Planning Application No BN/16/22/PL
Erection of 4 No dwellings with associated car parking, rear of Clare
Court, 67 Barnham Road, Eastergate

**OBJECTION – THE REQUIRED TREE SURVEY INFORMATION
SUBMITTED BY THE APPLICANT CONTAINS A MISLEADING
REPRESENTATION OF MATERIAL FACTS**

PROPOSED SITE PLAN . Scale 1:250 at A3

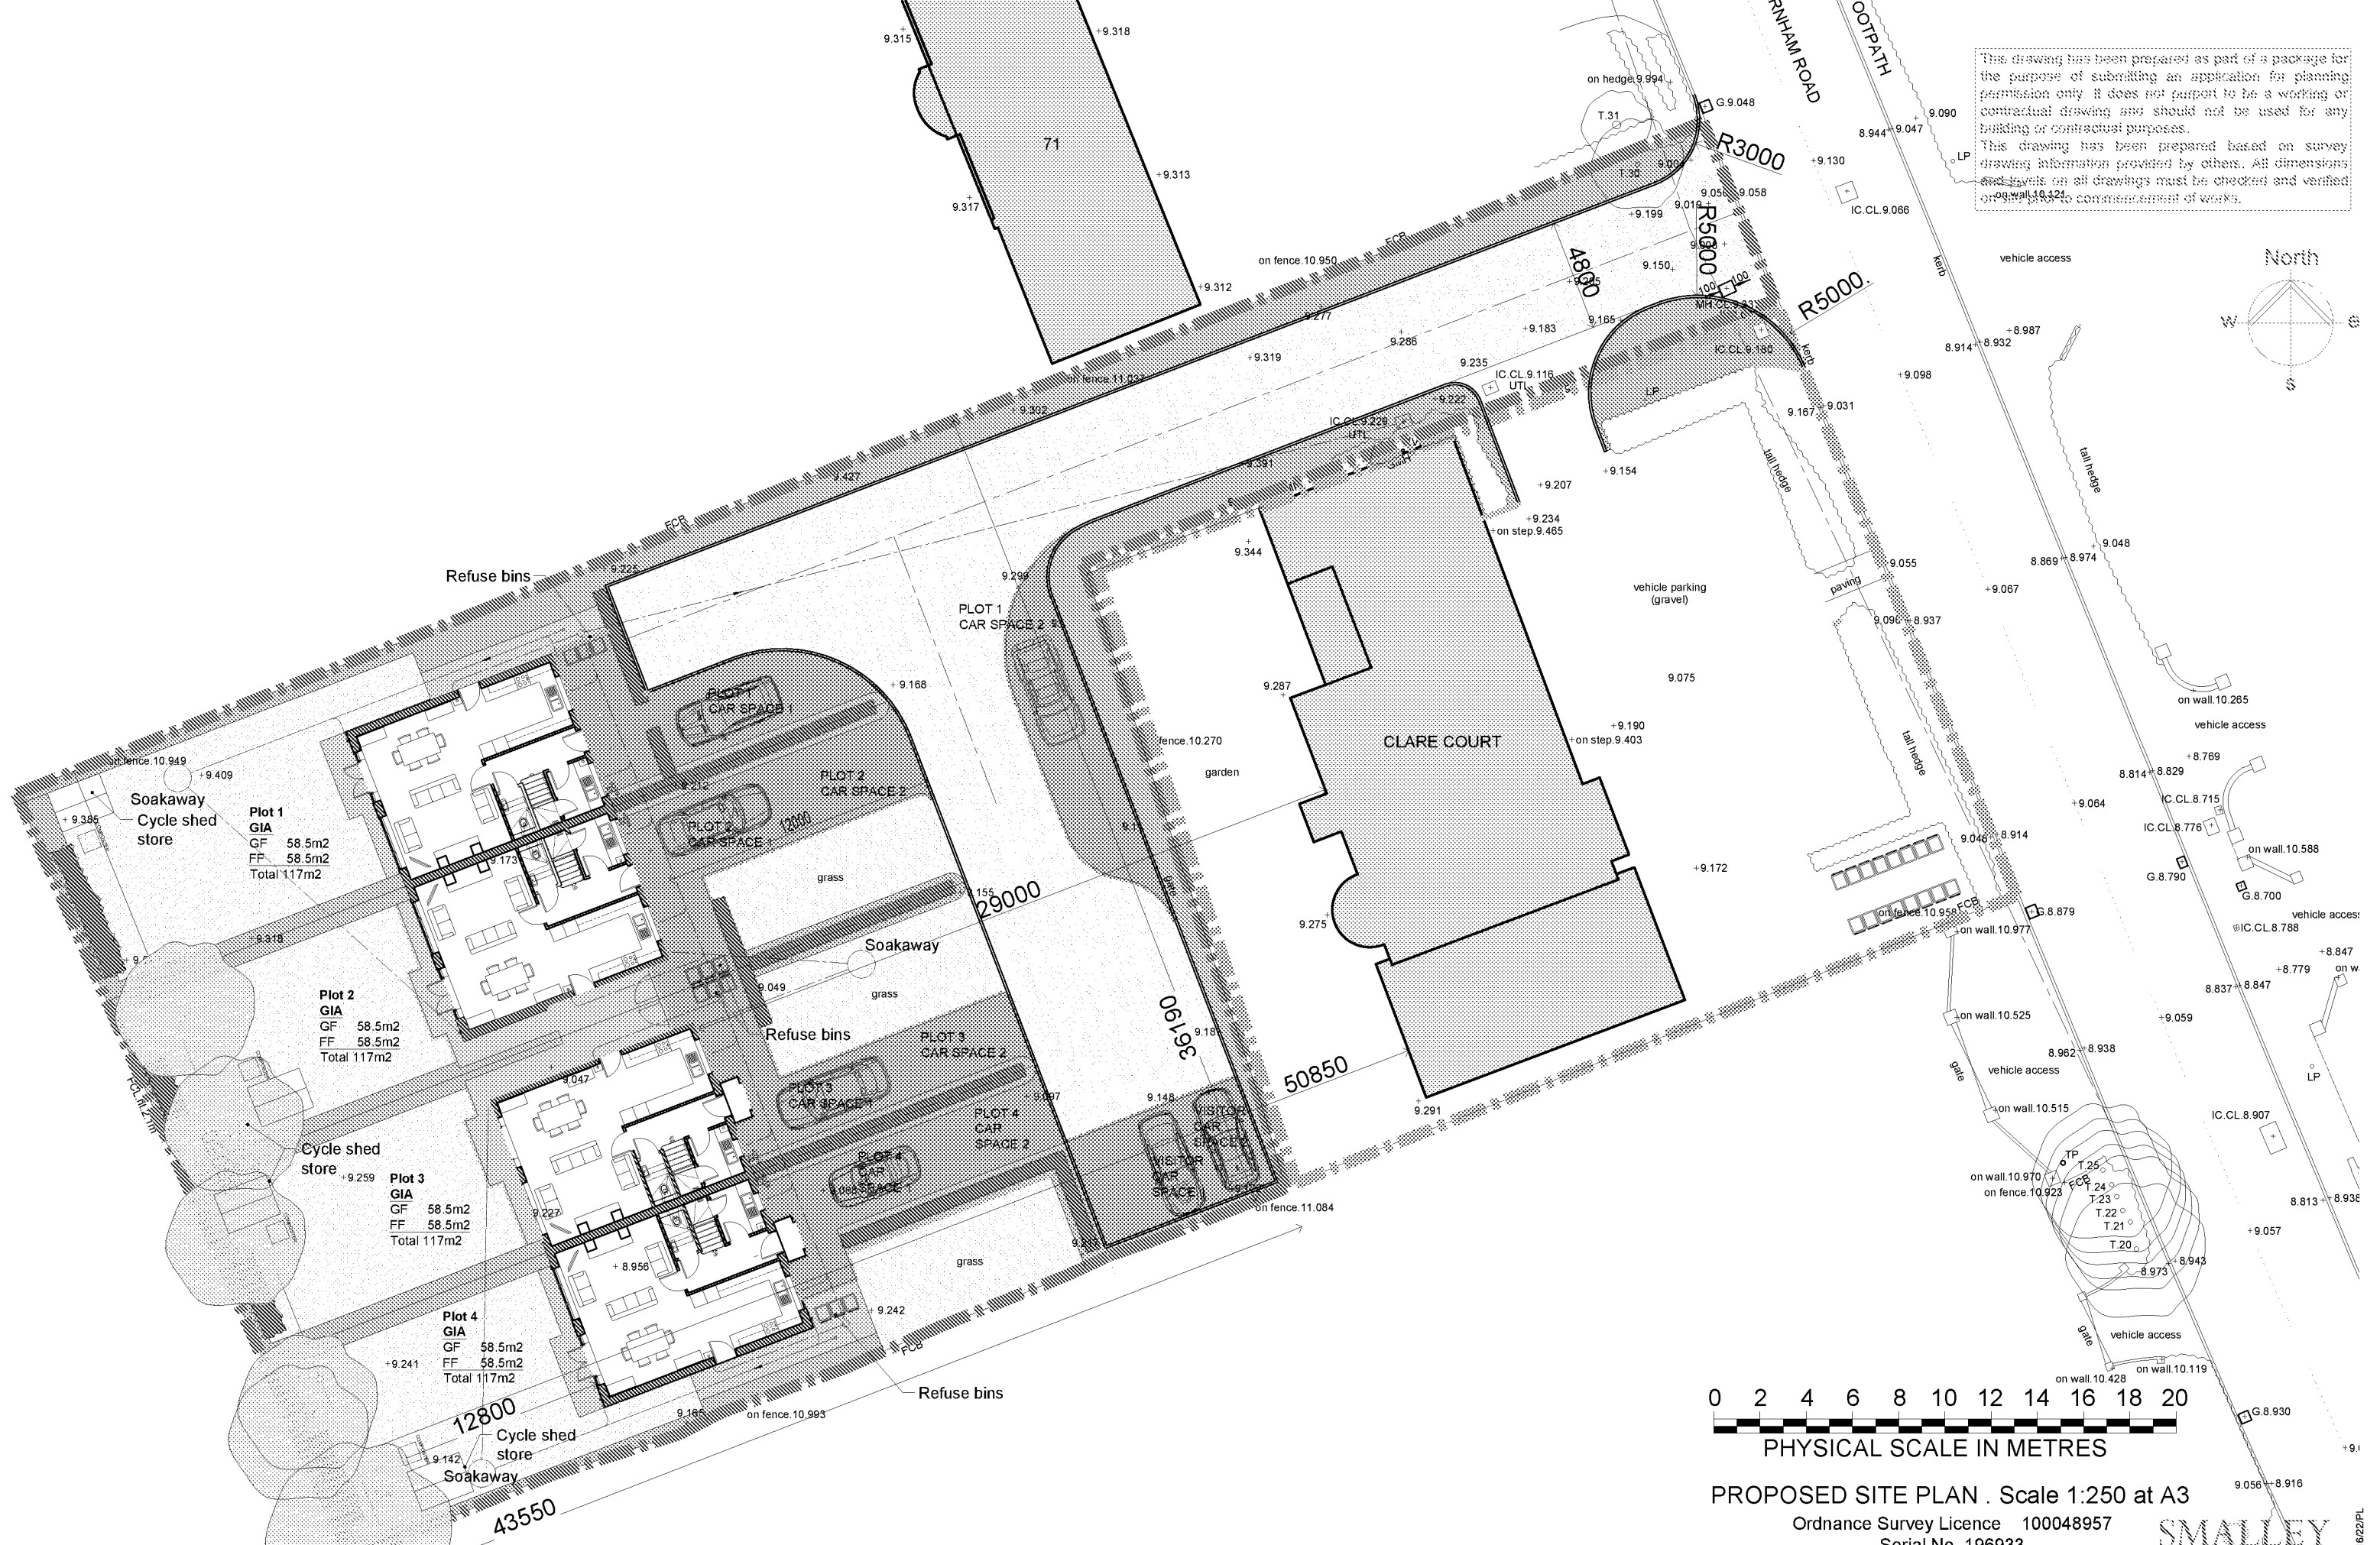
- 4.2 The boundaries of the development site are clearly shown, marked out in red, on the Proposed Site Plan ref 1474/05f. The development site can be seen to extend from the main road to the border with St Philip Howard School.

- 9.1 The Site Development Plan shows that the edge of the proposed new access drive for the development is **2 metres** from the border with our property, 71 Barnham Road, according to the scale shown on that plan.
- 9.2 The Yew tree stood where the access road is shown in the Site Development Plan, approximately 14 metres from the drive entrance. Its base extended to approximately **2.5 metres** from the border with No 71. Thus, the base of the tree is located approximately **half a metre** into the proposed access road.

- 9.3 The Scots Pine also stood where the access road is shown in the Site Development Plan, approximately 8 metres from the drive entrance. Its base extended to approximately **2.3 metres** from the border with No 71, again partly within the positioning of the new access road to the extent of approximately **30 centimetres**.
- 9.4 The arithmetic is simple, and its implications are obvious: ***It would not be possible to construct the access road according to the submitted plans without first destroying the Yew and the Scots Pine***, both of which were required by the planning polices to be protected and retained.
- 9.5 This is despite the assertion in the tree survey and in Section 6.6.1 of the Planning statement that ***no trees require removal or pruning to enable the development to go ahead.***
